From: Planning Consultation Mailin <planningconsultation@yorkshirewater.co.uk>
Sent: 01 July 2026 08:43
To: Planning ContactCentre
Subject: RE: Attached letter from Kirklees Council regarding application number 2026/91242 at location adj, 42, Long Croft Street, Golcar, Huddersfield, HD7 4EA

Given that the original application (2025/92628) has been granted, the only condition by which this could be addressed is via Condition 2 (approved plans) as from Yorkshire Water's perspective, the submitted drainage plan is not acceptable. It is worth noting that the Drainage Plan submitted on the granted decision (2589 – D – 20 – 006) is different to that submitted under this discharge of condition (2589 – D – 20 – 004 – B) but would require formally reviewing.

Drawing Number: 2589 - D - 20 - 004 - B
 Revision: B
 Do not scale from this drawing. Work to original dimensions, and any discrepancy to be reported to the Architect.
 Refer to larger scale drawings where available.

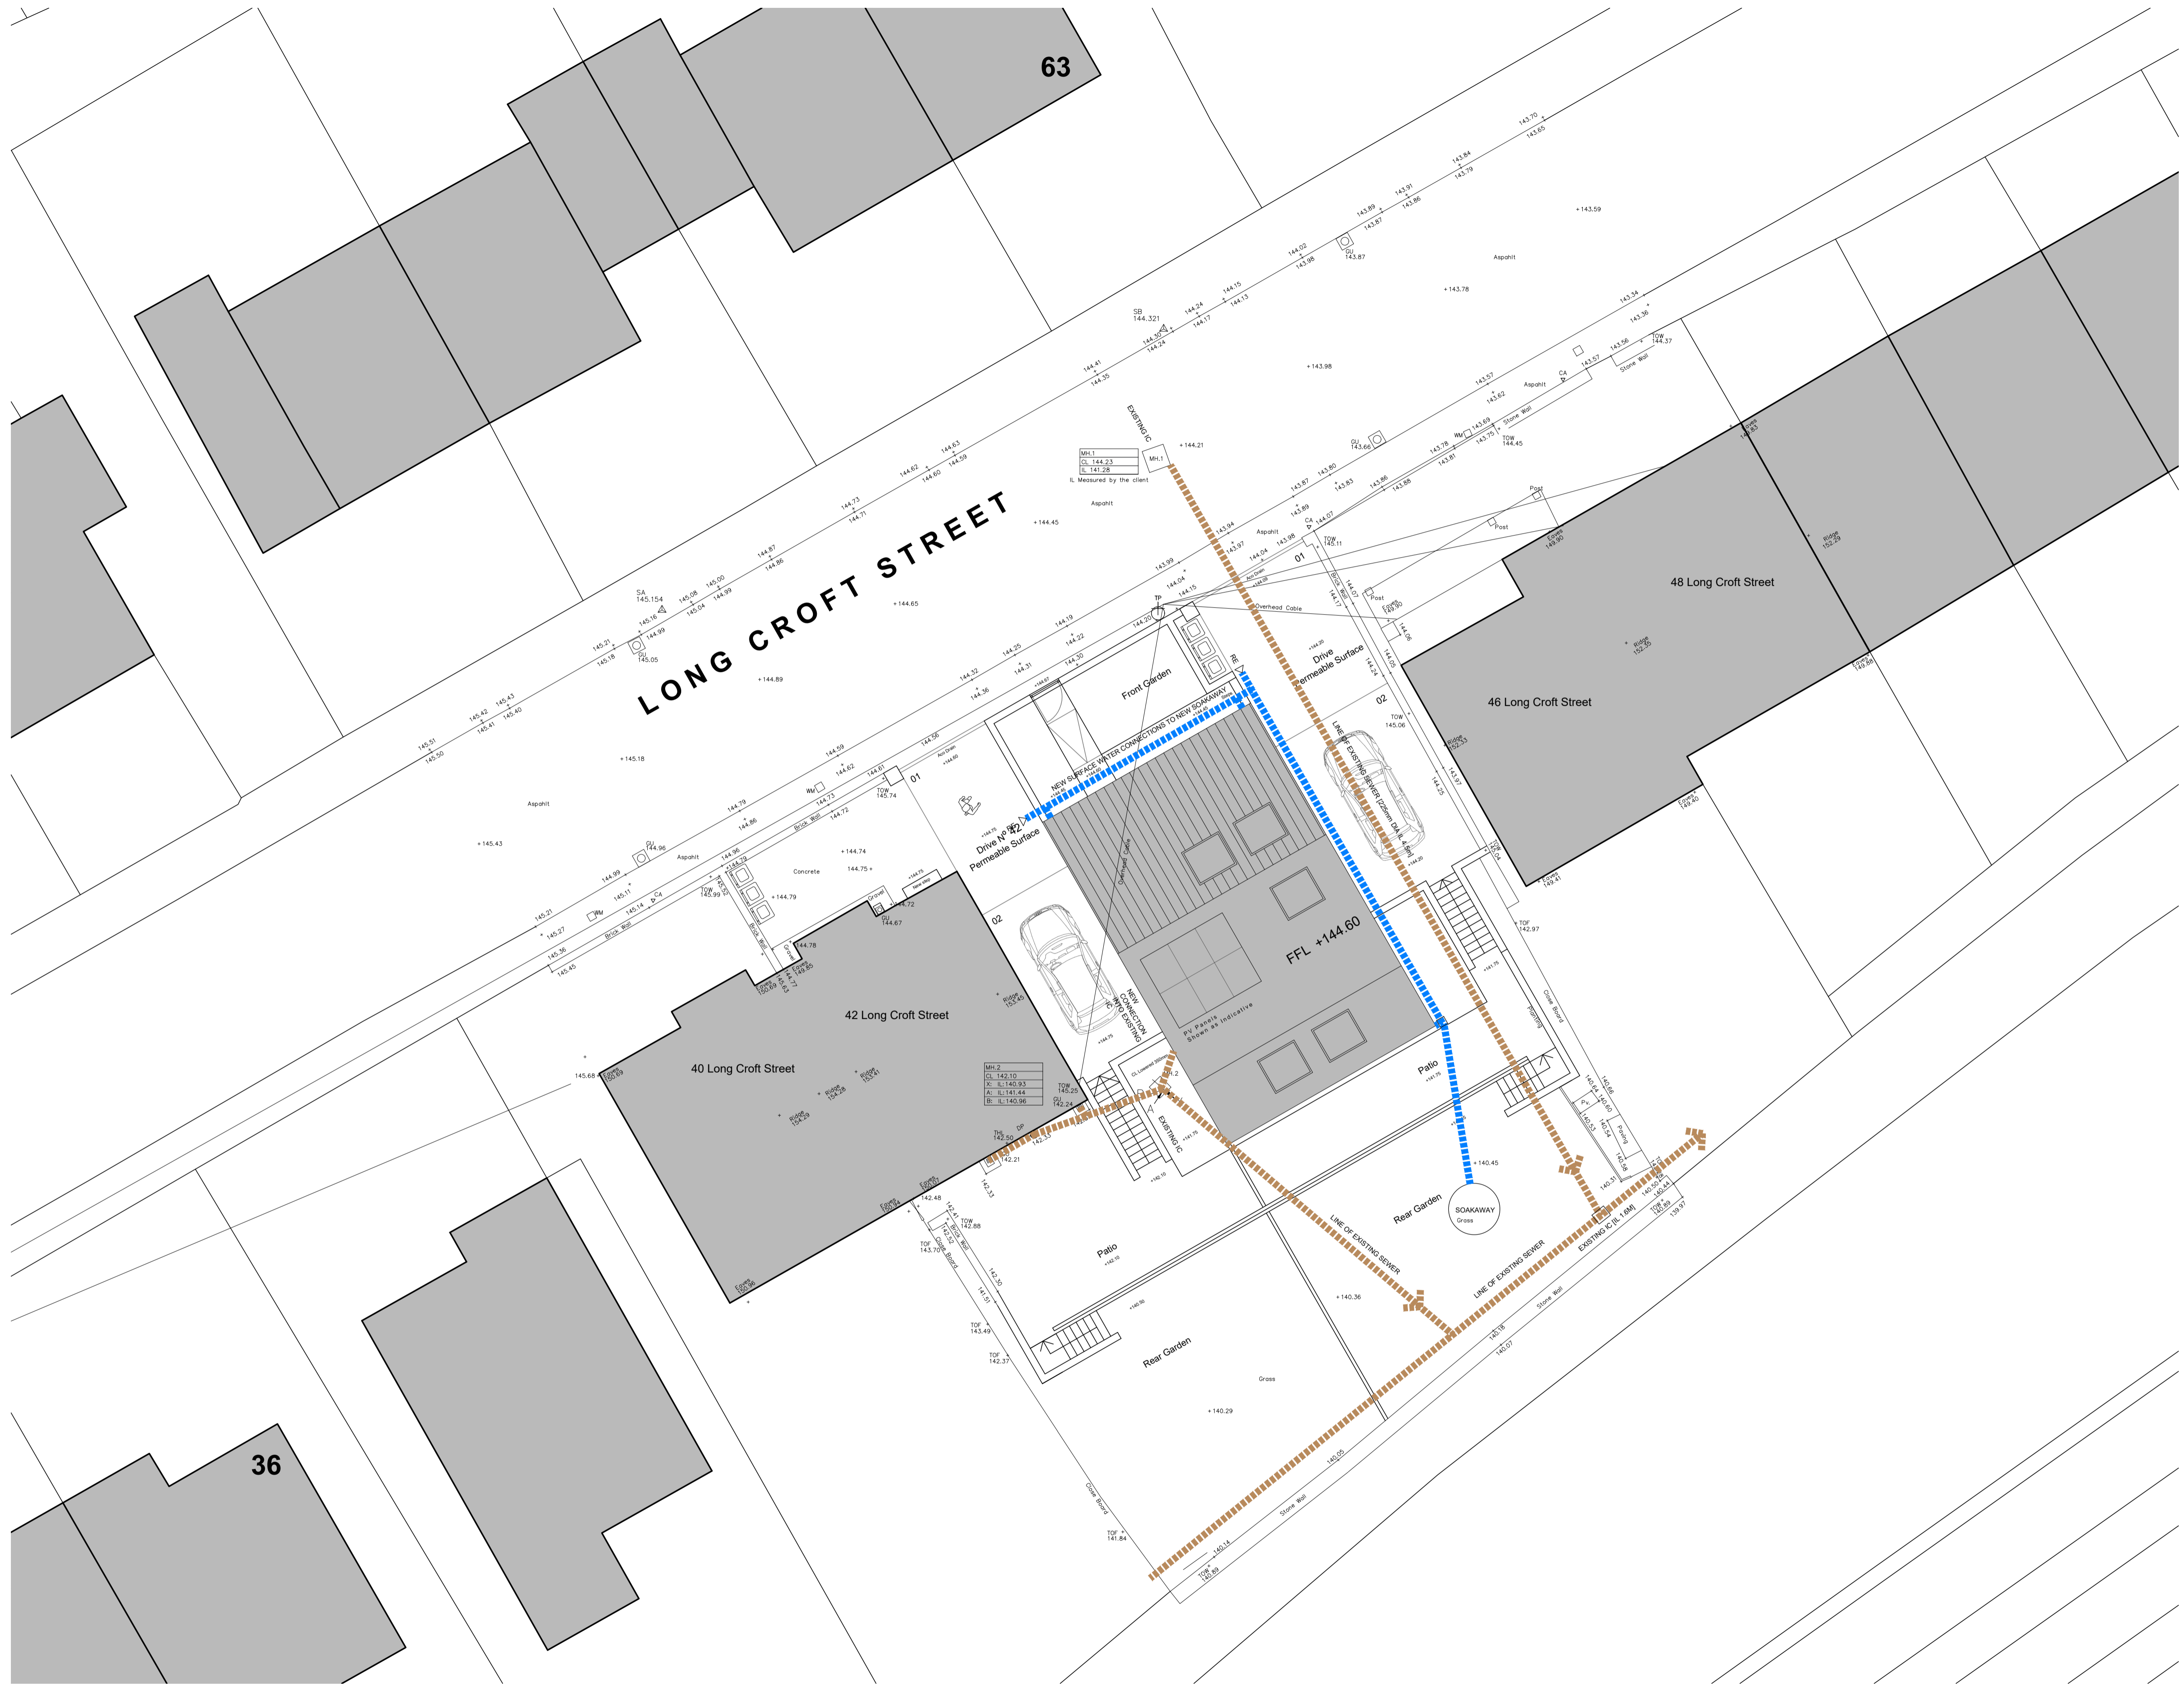
It appears that neither condition 6 or 8 relate to drainage and therefore are not relevant to Yorkshire Water. Though, I would like to remind you that there is an outstanding objection from us, this is in relation to the drainage plan which shows building over within the stand-off distance from a public sewer crossing the development. This could seriously jeopardise our ability to maintain the public sewerage network.

Therefore, please may I kindly ask that the drainage plan/site layout is reviewed by the agent/applicant and an amended layout is submitted in writing in relation to Condition 2.
